CLITHEROE TOWN COUNCIL

14 February, 2012

Objection to Planning Application 3/2011/1064

Whilst welcoming the provision of 32 affordable homes the Town Council cannot support the application as set out for the following reasons

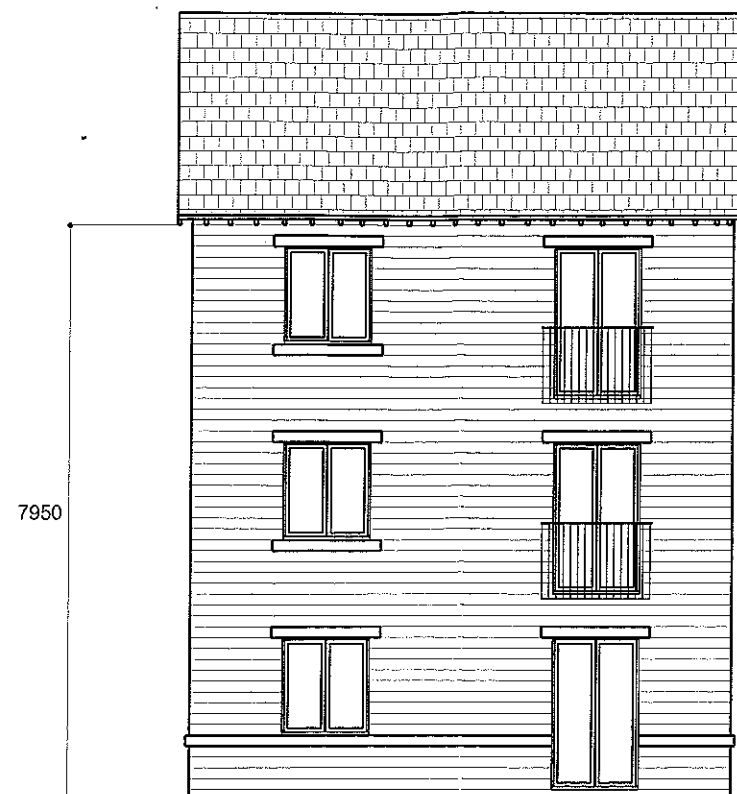
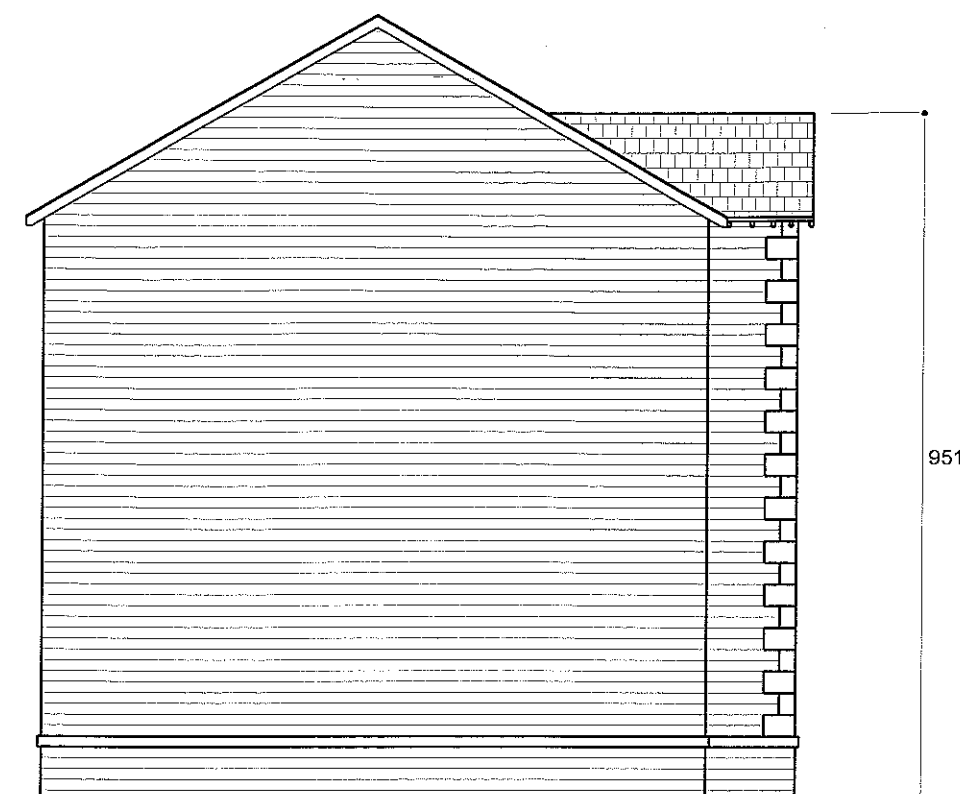
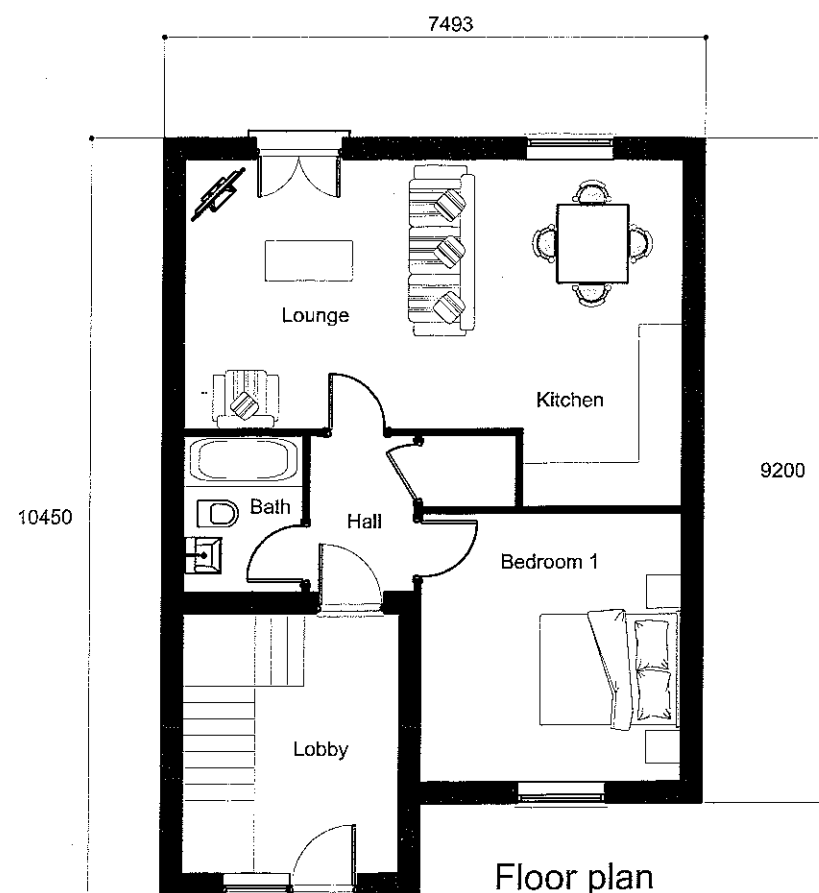
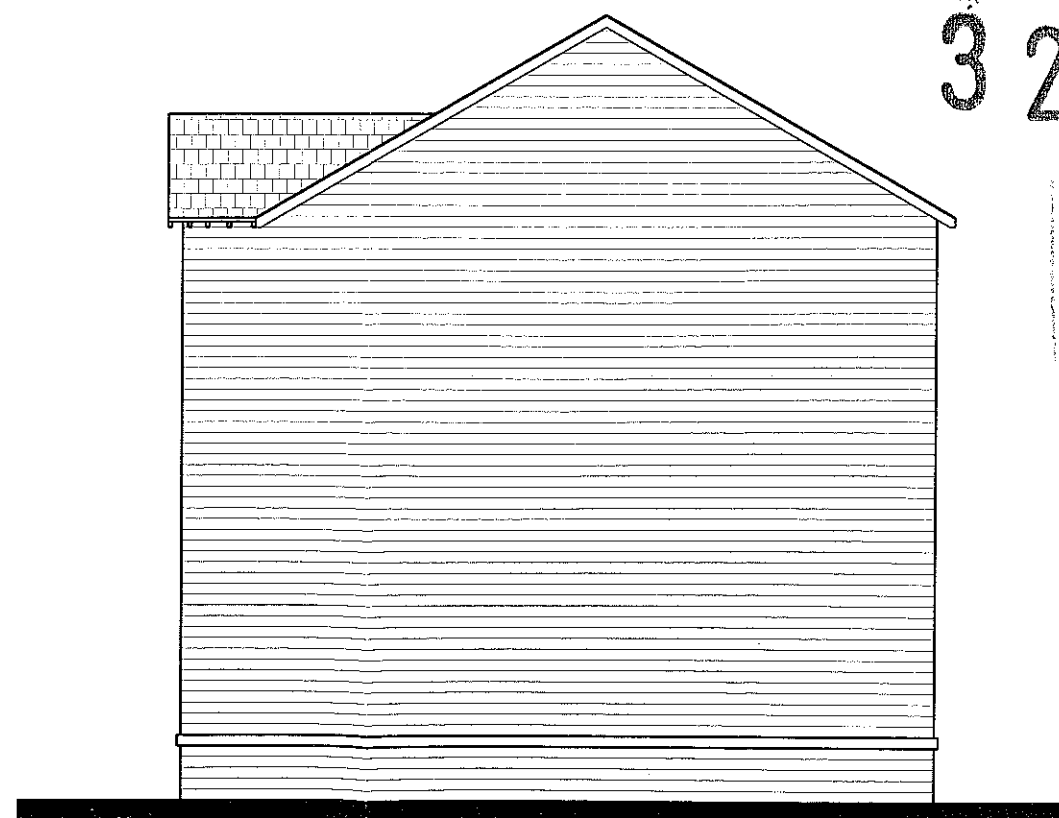
The Mearley Croft proposal also includes at plots 1-3 3 storey building facing onto Woone Lane. These would seem in out of keeping with the current Victorian Street scene.

Revision	Description	Date
CLIENT		
BECK DEVELOPMENTS LTD		
PROJECT		
Proposed Development at Land to the rear of No's 59-97 Woone Lane - Clitheroe		
DRAWING		
PLANNING LAYOUT		
SCALE	DATE	
1:500 @ A3	November 2011	
DRAWING NUMBER	REVISION	
3501/P/001	-

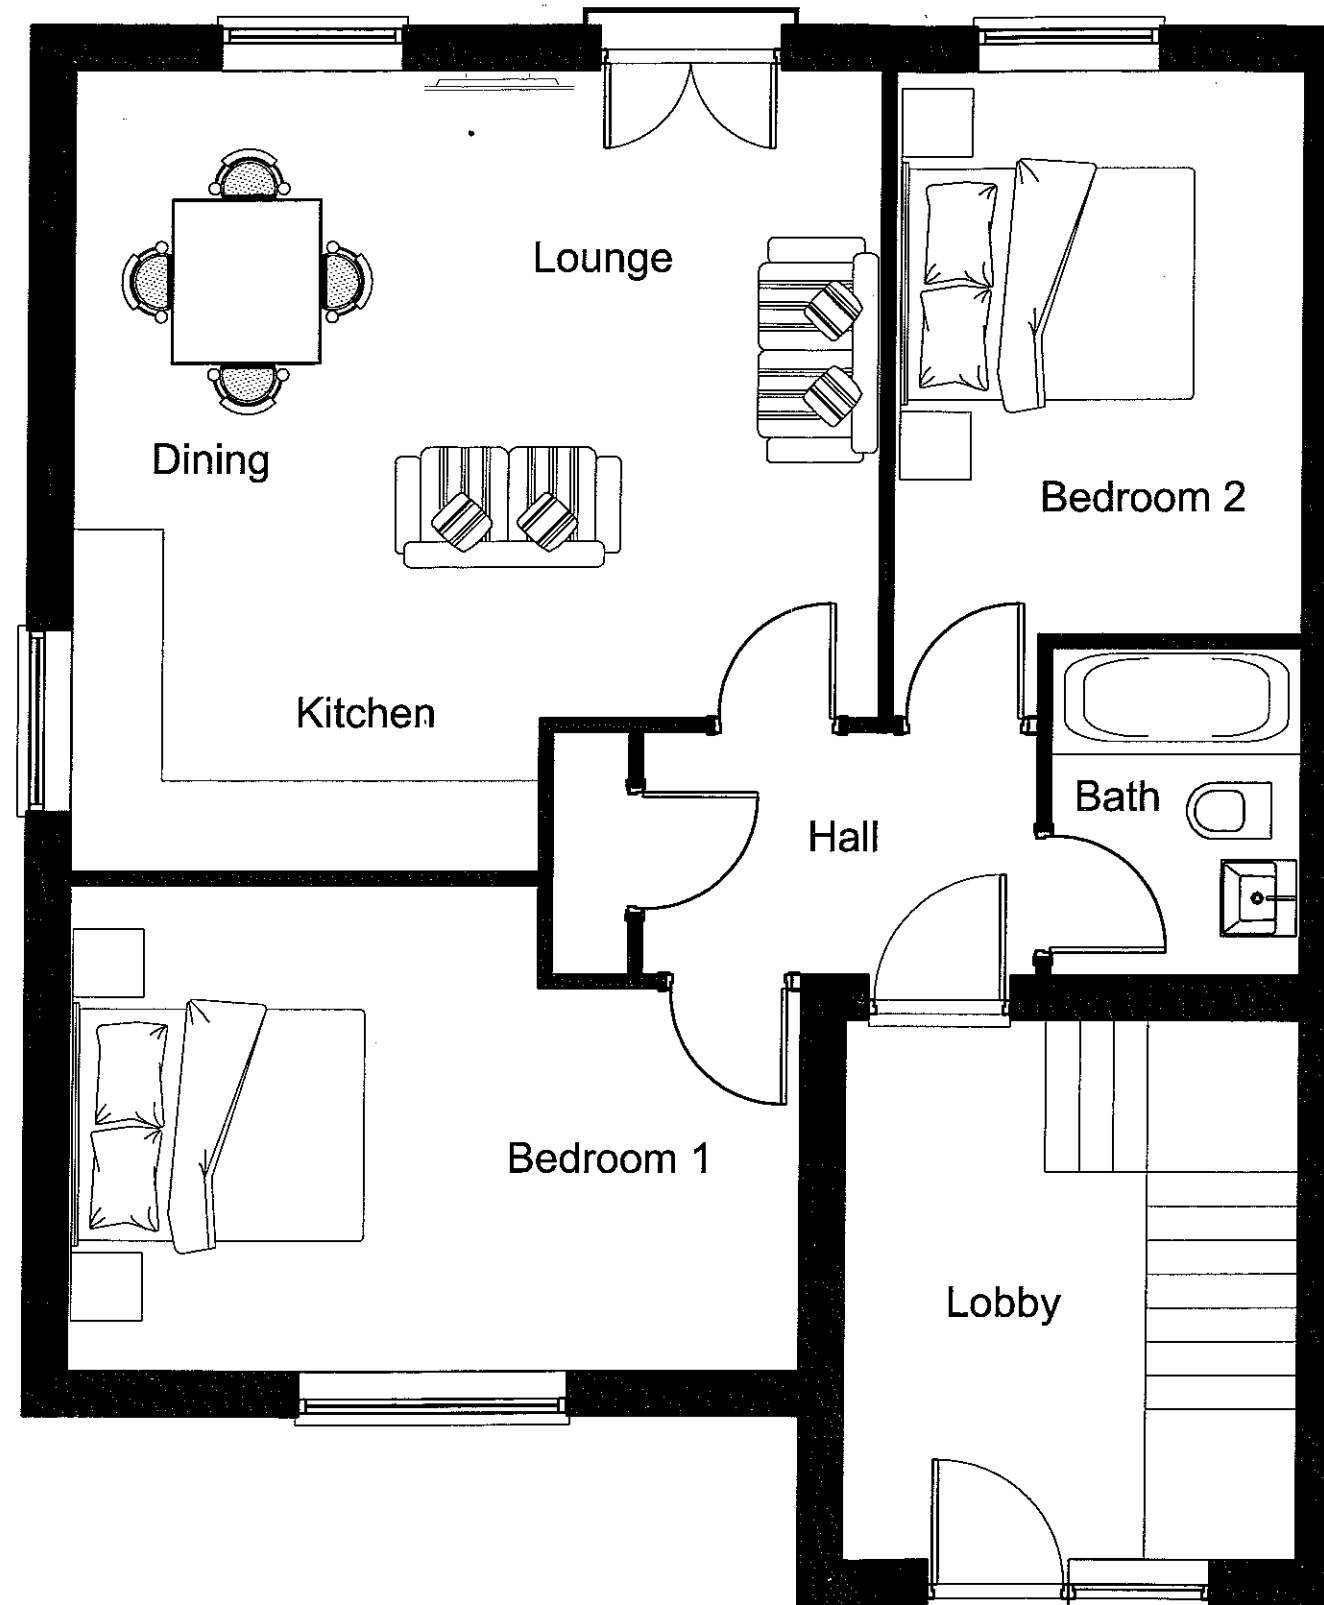
Council believes that despite the argument of the developer this cannot be treated as on site as there are four hundred yards and over 150 properties (most over 100 years old) between the plots.

This is approximately the same as the Mearley Croft site, but not identical as the Southern end of the site (where plots 1-11 and the exit road are located) extends into the area that was zoned for environmental development only. This would appear to be in contravention of policy A1

In addition the eastern half of Mearley Croft has extended out of the area into zoned for housing development in A1 into an area of the lodge that according to the Environment Agency is prone to extreme flooding. It should be noted that residents between 59-97 Woone Lane have already had problems in insuring their properties – the problem would only be exacerbated for those nearer the brook.

The proposed access into Mearley Croft is at one of the narrower parts of Woone Lane, when the most satisfactory is opposite the Rectory or Victoria Street.
